Town & Country Planning Act 1990 (as amended)
Town & Country Planning (Development Management Procedure) (England) Order 2015
Application for Planning Permission for Works or Extension to a Dwelling

Development Addition of a first floor and carport with 1st floor.

Location Strawberry Cottage Cypress Way Aldwick

Drawing:
Ground floor as proposed

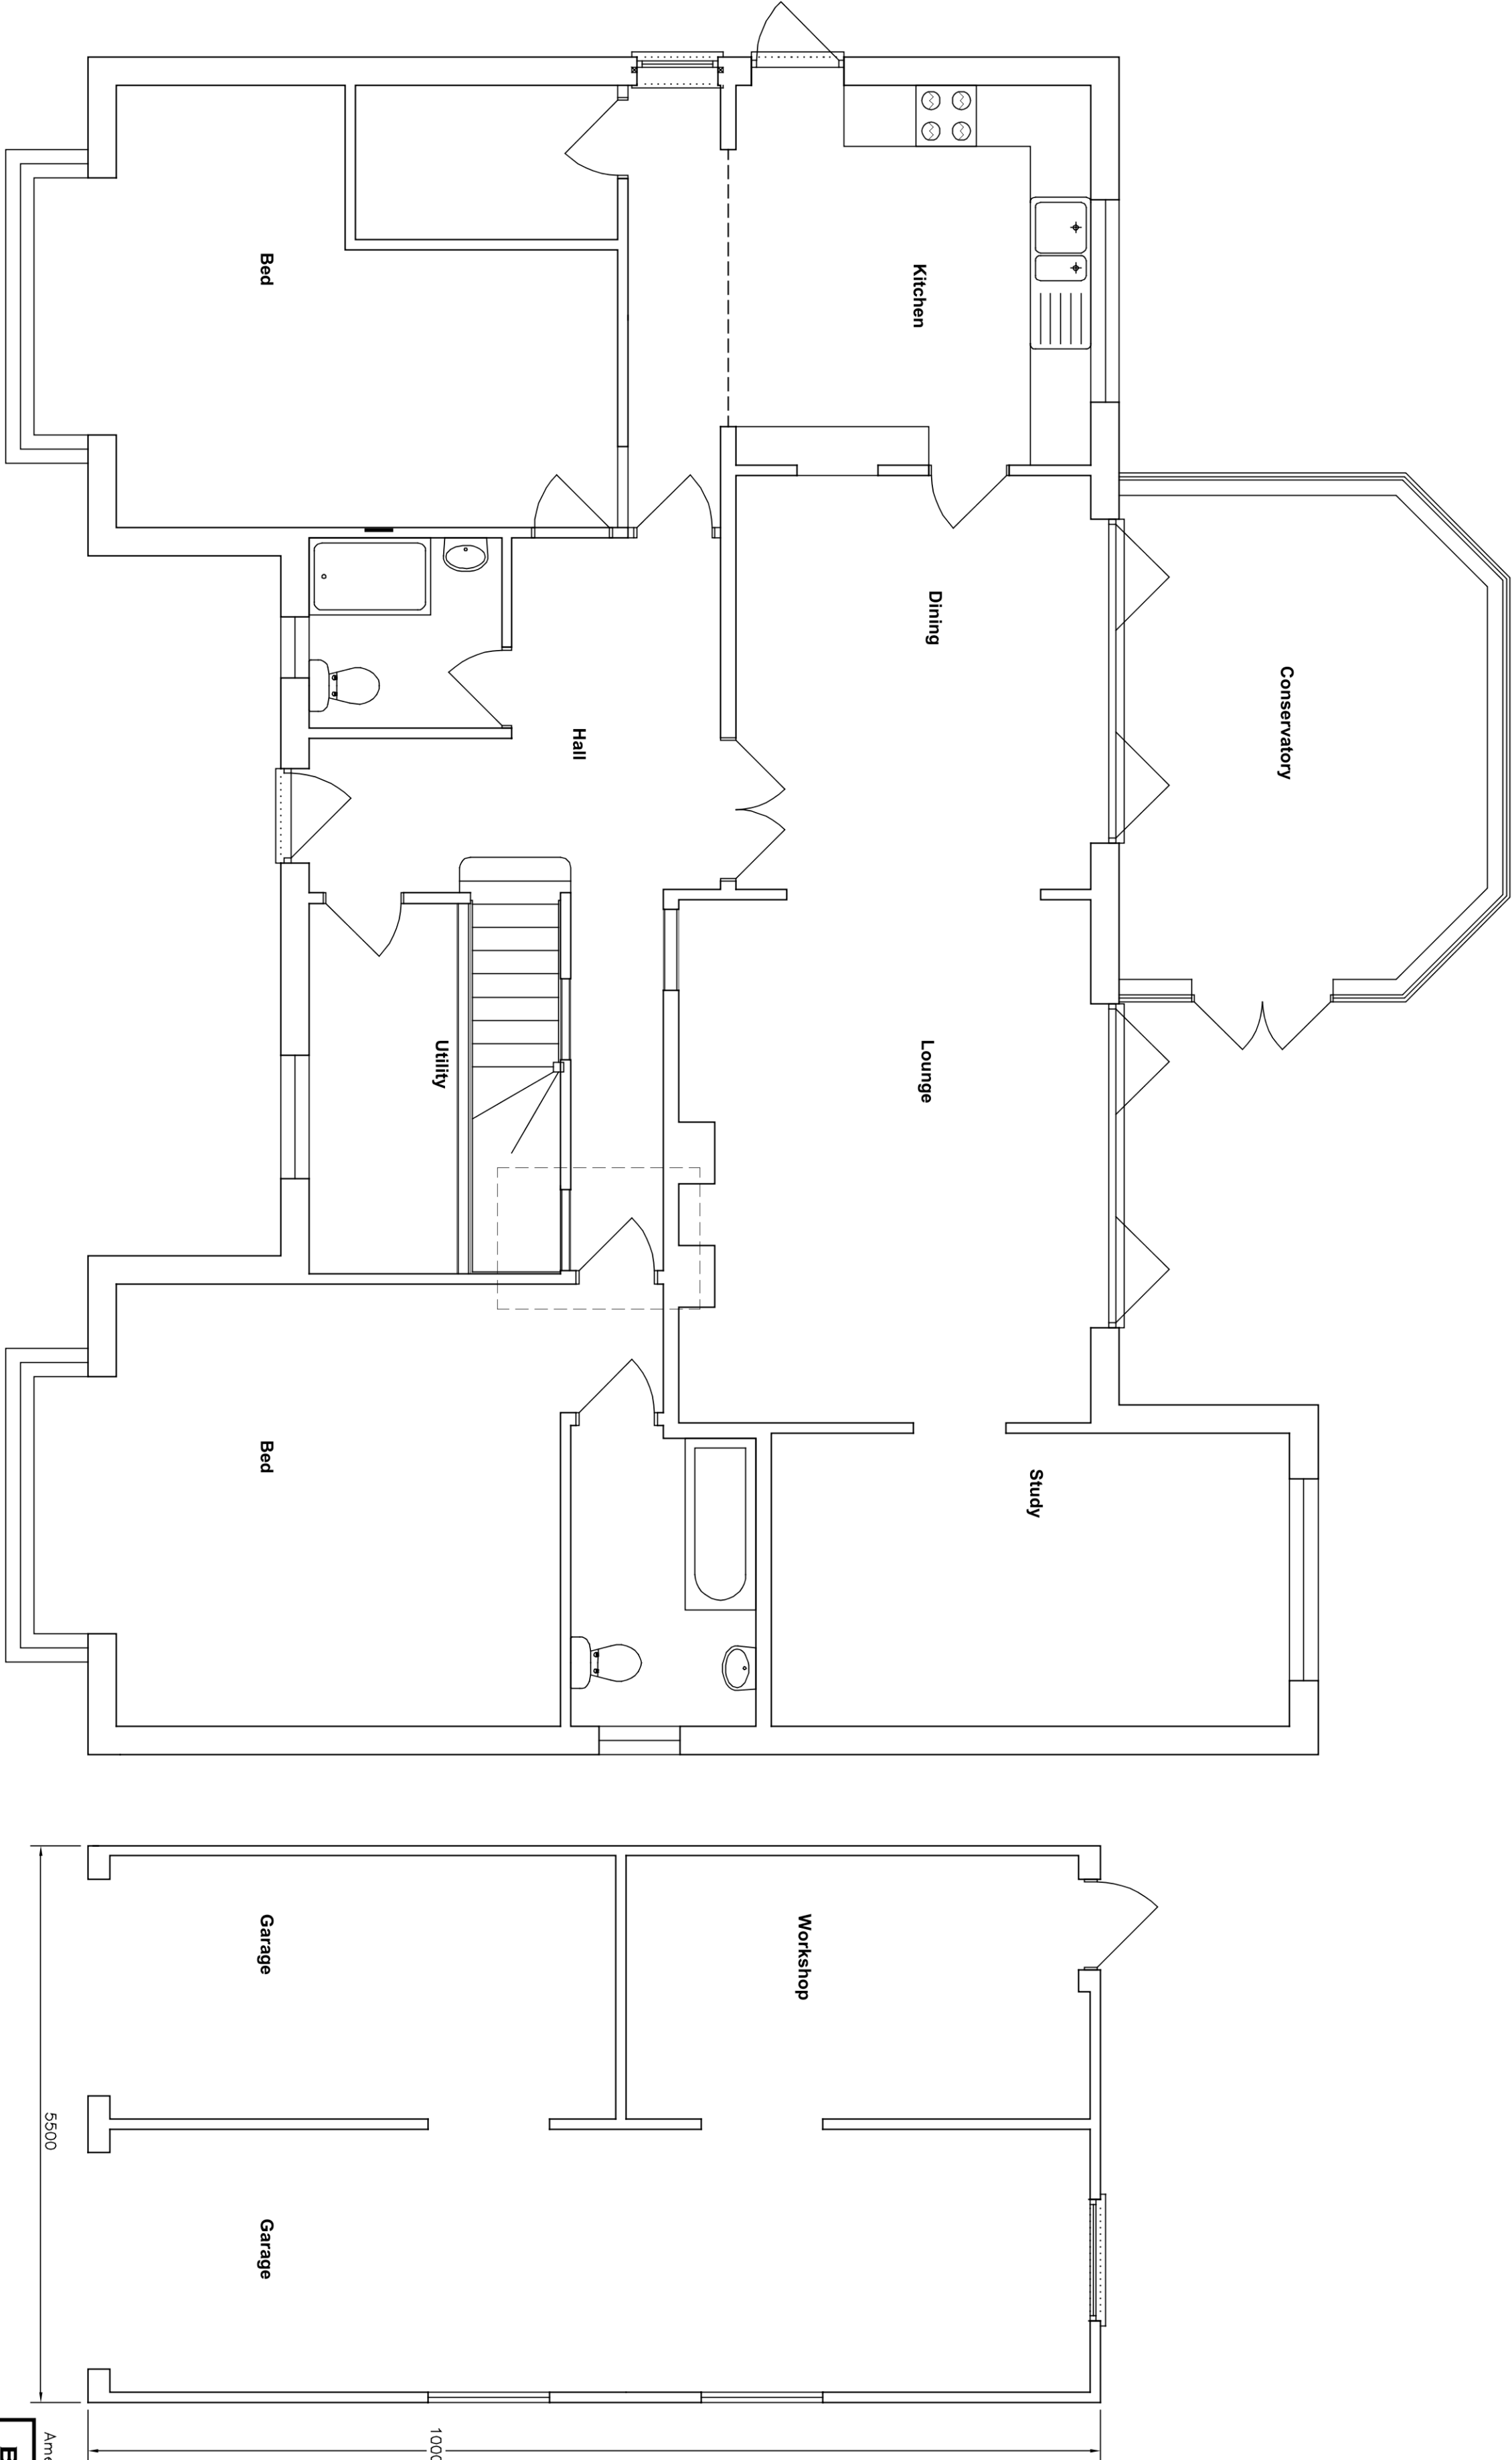
Room Labels: You are required to have room labels on all of your floor plans.

Drawing:
Proposed car barn and storage

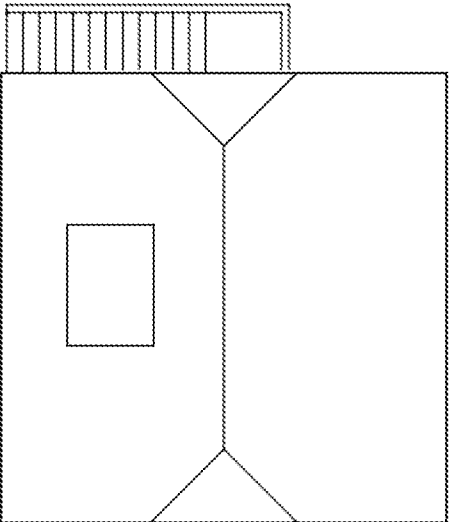
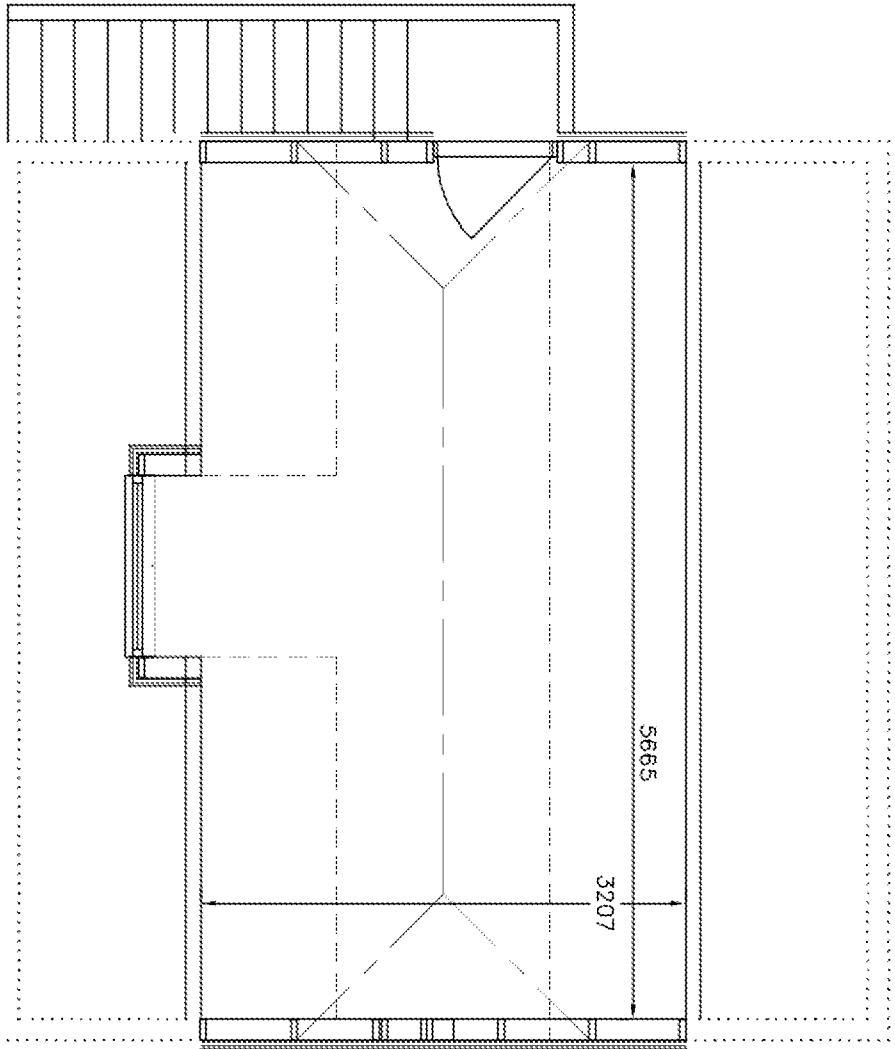
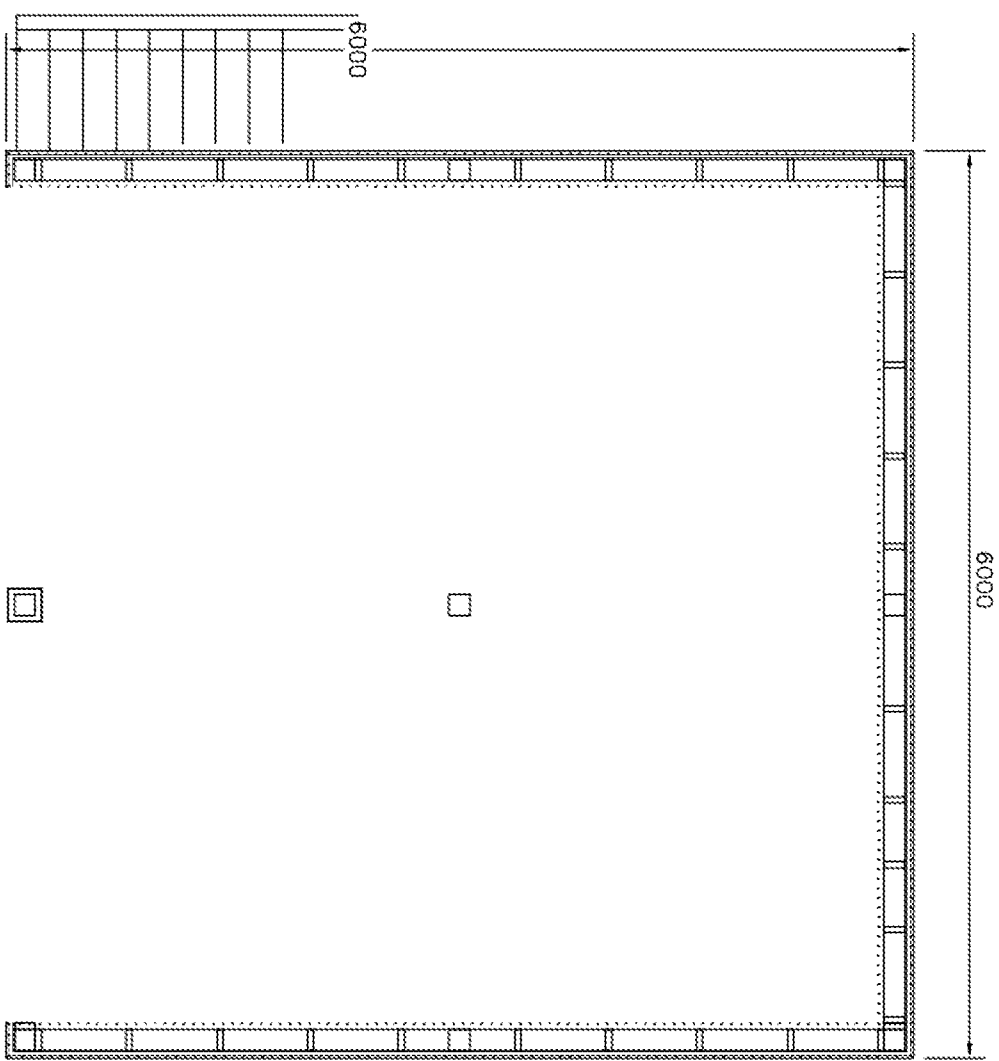
Carport: The height of the roof is inconsistent on the carport. Please amend.
